Office of Water

7 February 2011

**Gwandalan residential subdivision – Project Application (MP10_0205)
Environmental Assessment**

**NOW COMMENTS ON ENVIRONMENTAL ASSESSMENT
GWANDALAN RESIDENTIAL SUBDIVISION – PROJECT APPLICATION (MP 10_0205)**

Stormwater Catchments			
Council:	Wyong	Projection:	M.G.A.
Datum:	A.H.D.	North Direction:	Grid
Source:	ADW Survey	Plan By:	MJH
Contour Interval:	1.0m (Des & Nat)	Checklist:	MJH

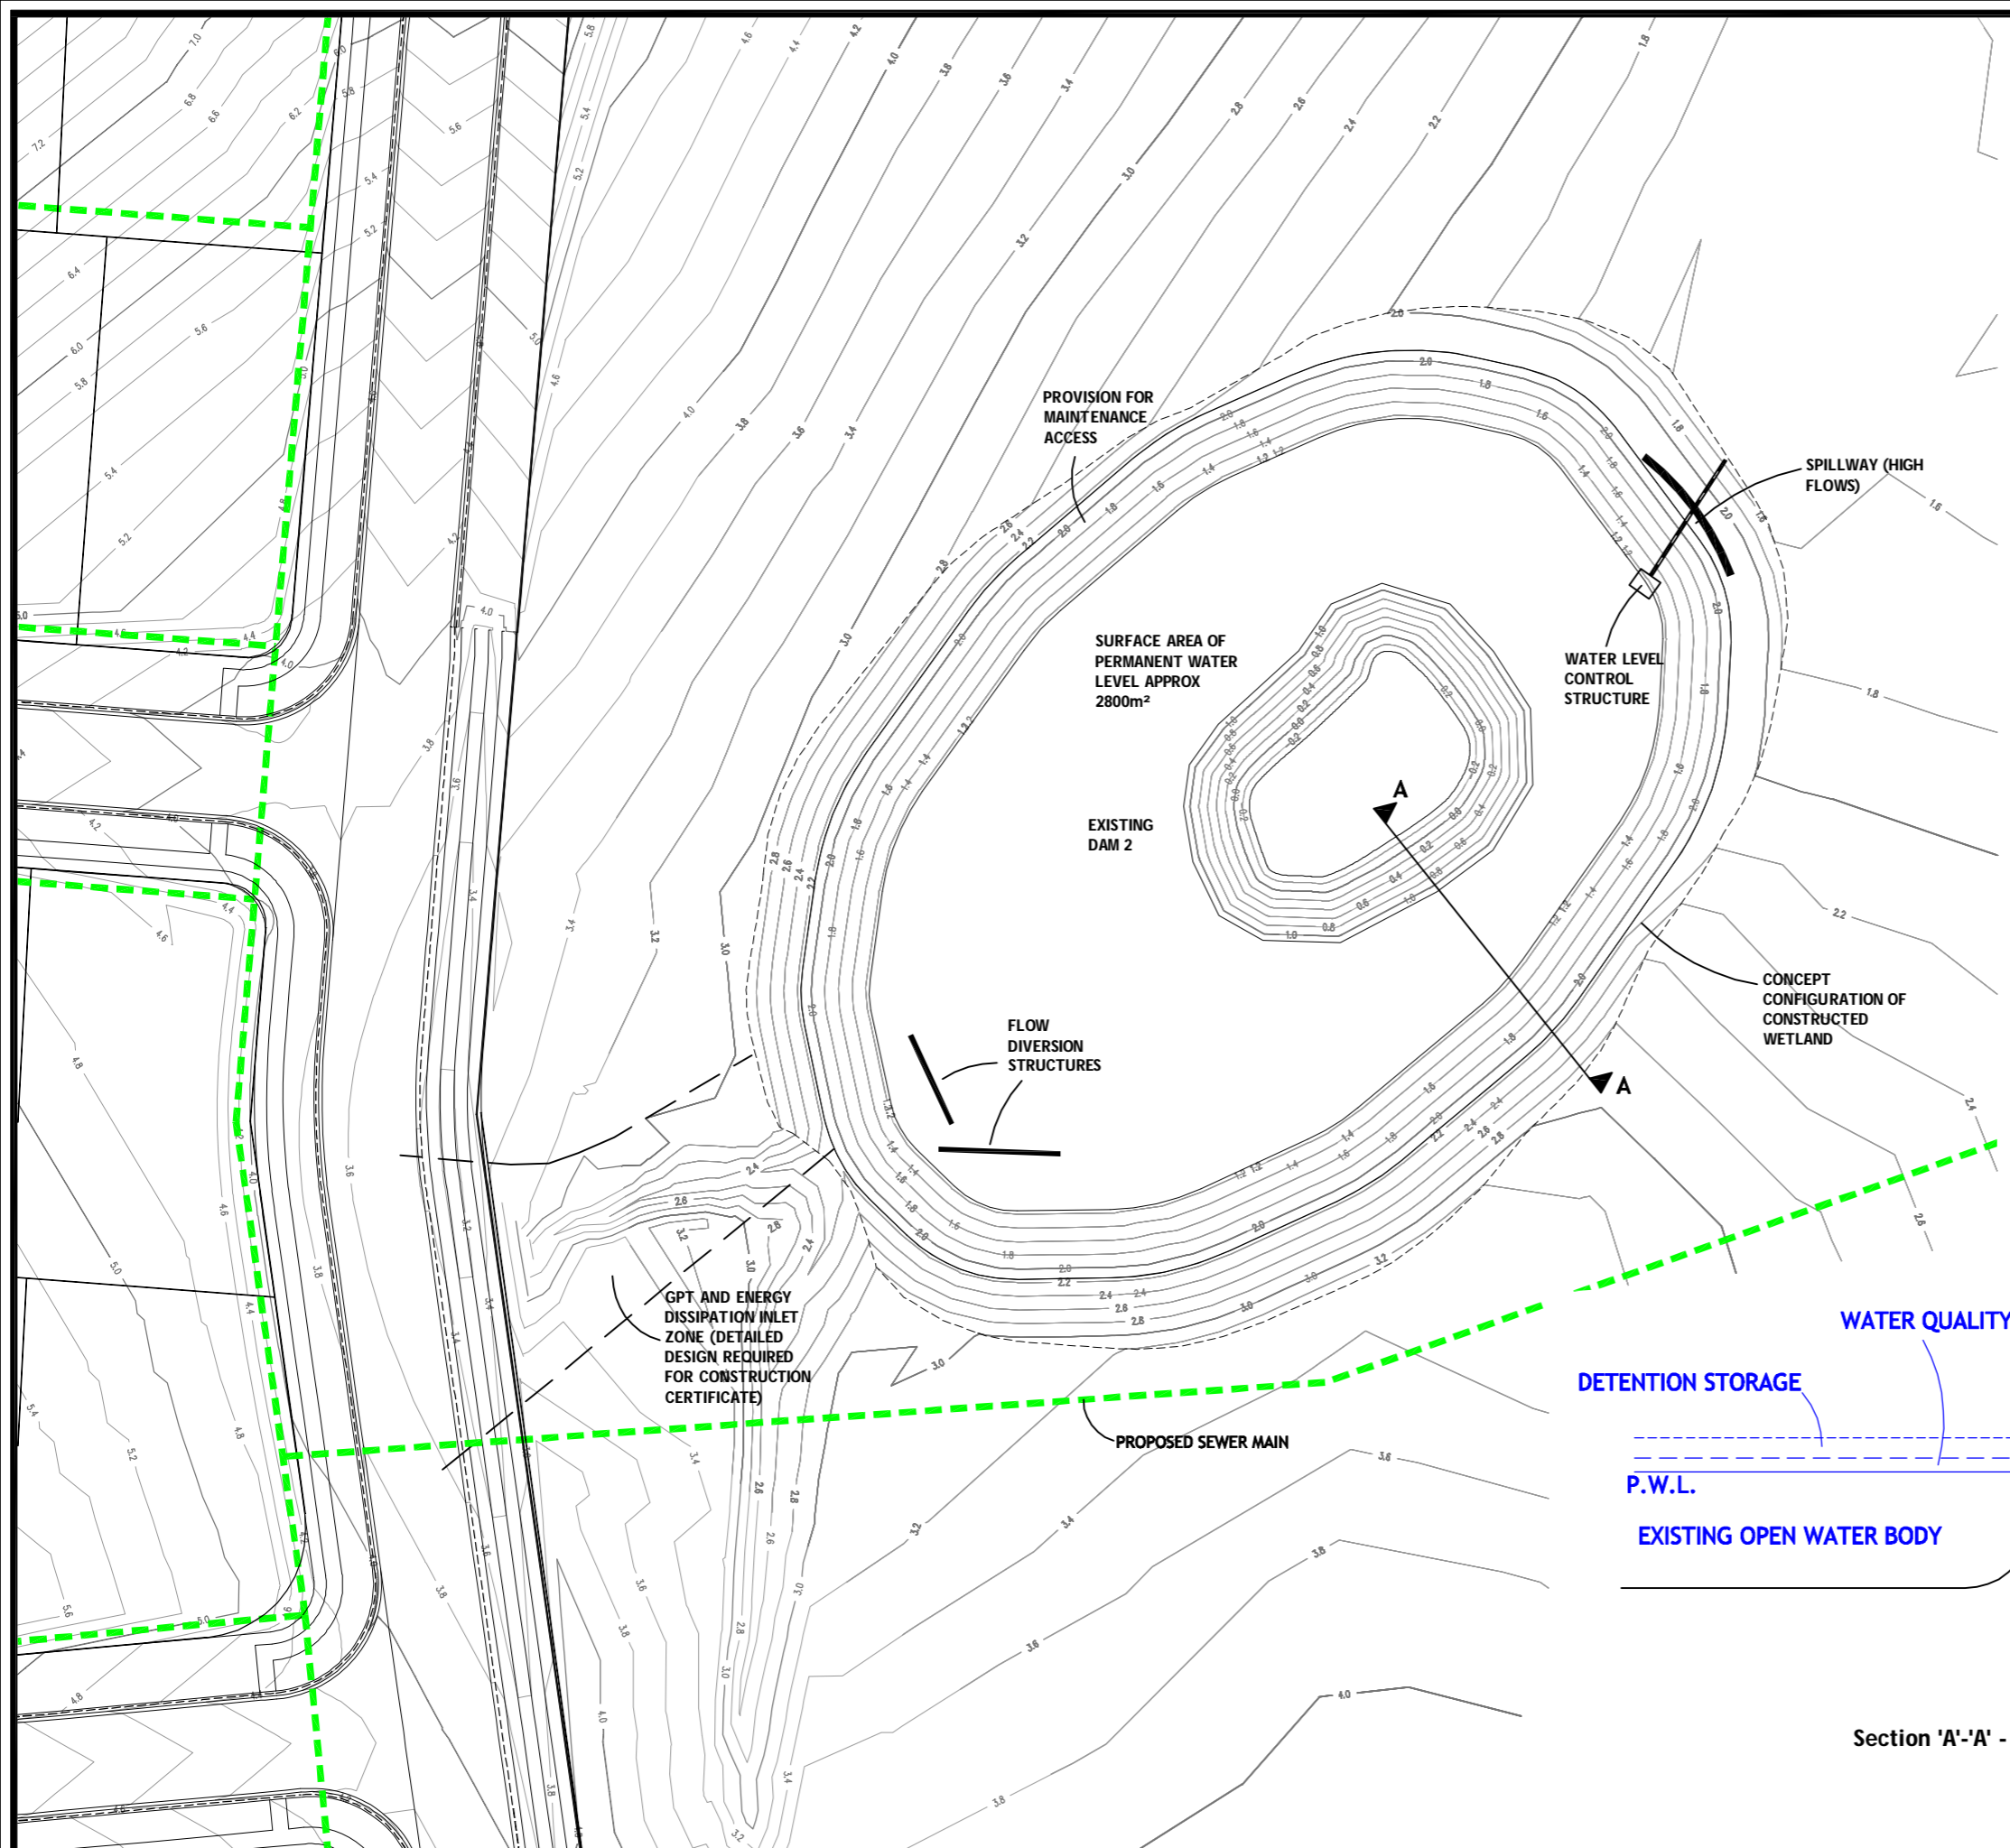
The proposed development removes a number of first order streams, with roads becoming the primary pathway for water. These roadways drain via a swale to the lower portion of the site, into a proposed detention basin. This detention basin uses an existing dam, reshaped to provide macrophyte beds for water quality as well as detention functions. The section of watercourse from the swale to the detention basin will require a designed inlet, as the velocity of flow in this area will be above that for which the stream is adjusted. This design will also need to consider the junction with the catchment from the south east park area, to ensure that there is no potential for an erosional knick point to form. Re-establishment of riparian zone vegetation upstream and downstream of the detention basin should also occur, including the watercourse through the South East Park, if required.

Sheet  
**501**

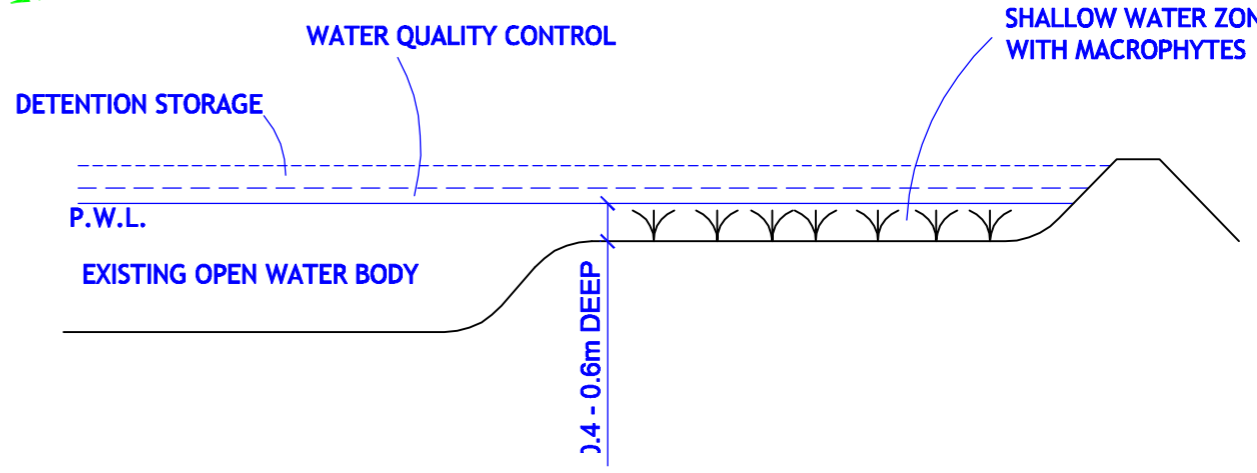
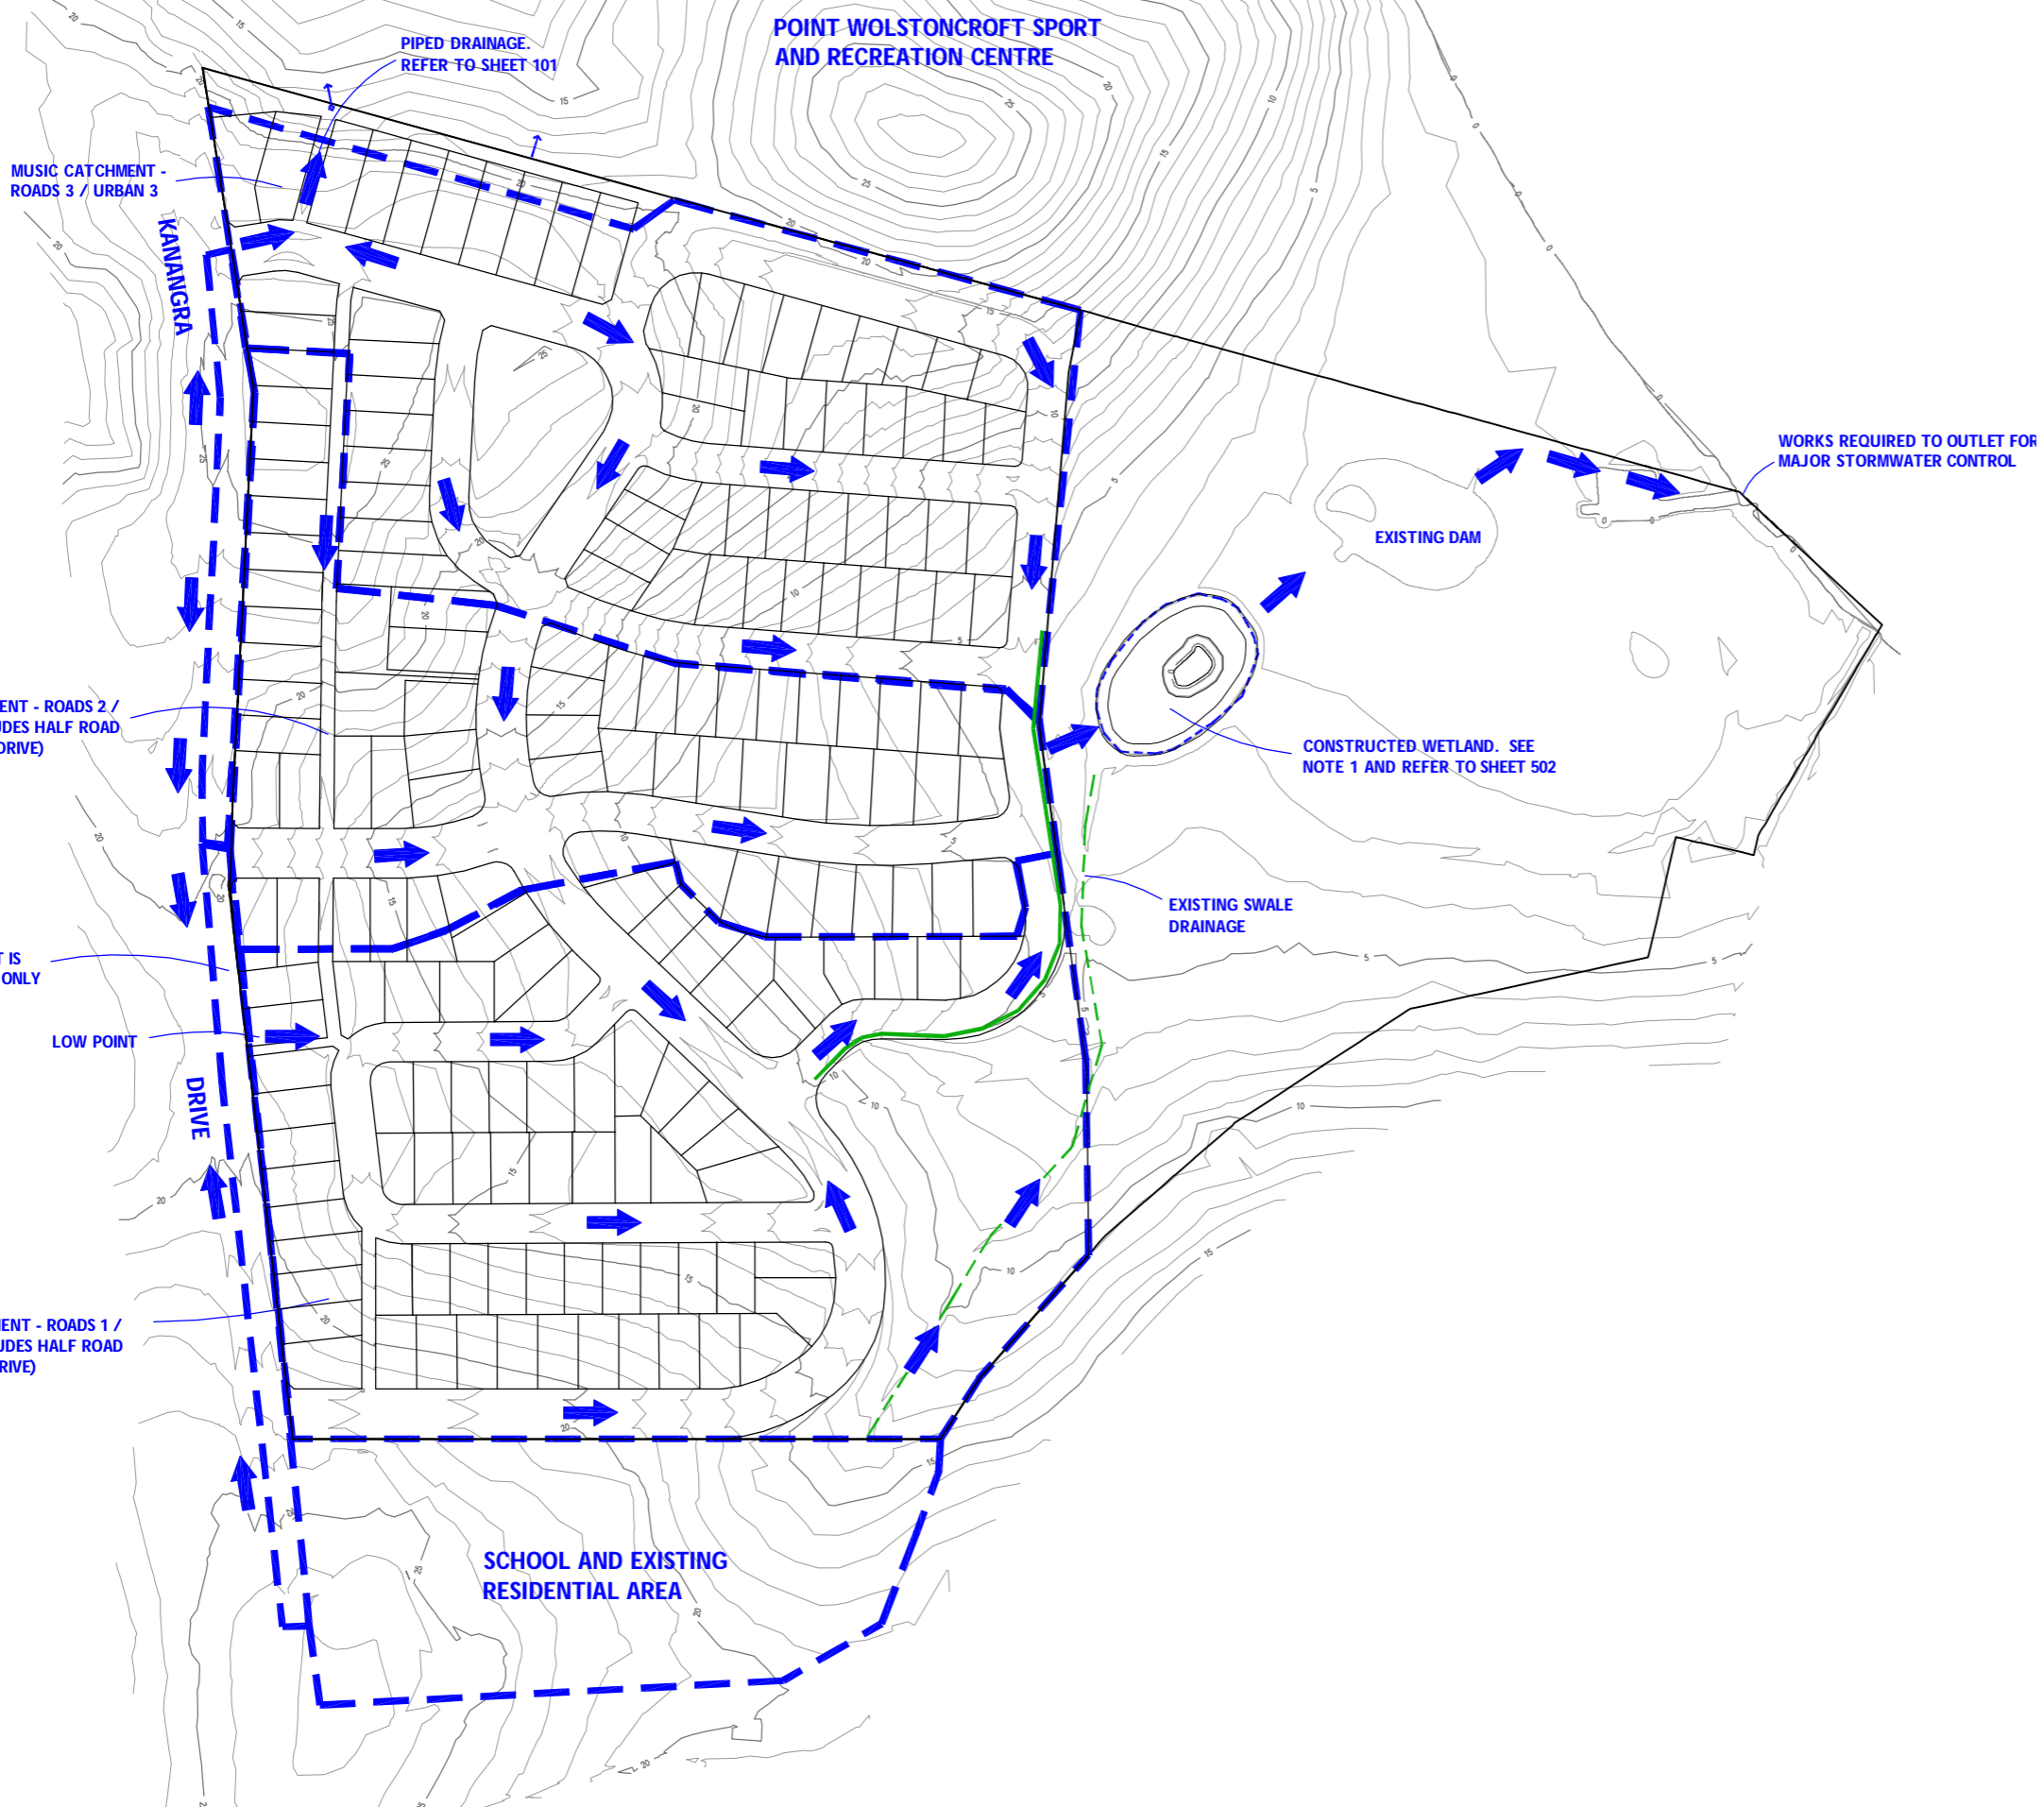
The EA provides concept plans of the detention basin only. Detailed design of the detention basin, riparian zone rehabilitation and the reshaping of the creek entrance (referred to in section 7.1 of Appendix H) should be undertaken to the satisfaction of NOW prior to commencement of construction. The proposed detention basin should be lined to ensure that infiltration to groundwater does not occur.

- 2.1. A Riparian zone management plan should be prepared to the satisfaction of NOW for the stream passing through the south east park, and below the swale drainage. The plan should include:
 - 2.1.1. Detailed design of the stormwater detention basin, including volume of water to be stored, appropriate lining;
 - 2.1.2. Design of the inlet structure to the detention basin, sized to avoid erosion;
 - 2.1.3. A riparian zone assessment and rehabilitation plan for the creek through South East Park into the detention basin, and downstream of the detention basin; and
 - 2.1.4. Detailed design of the rehabilitation proposed for the creek outlet to Lake Macquarie.
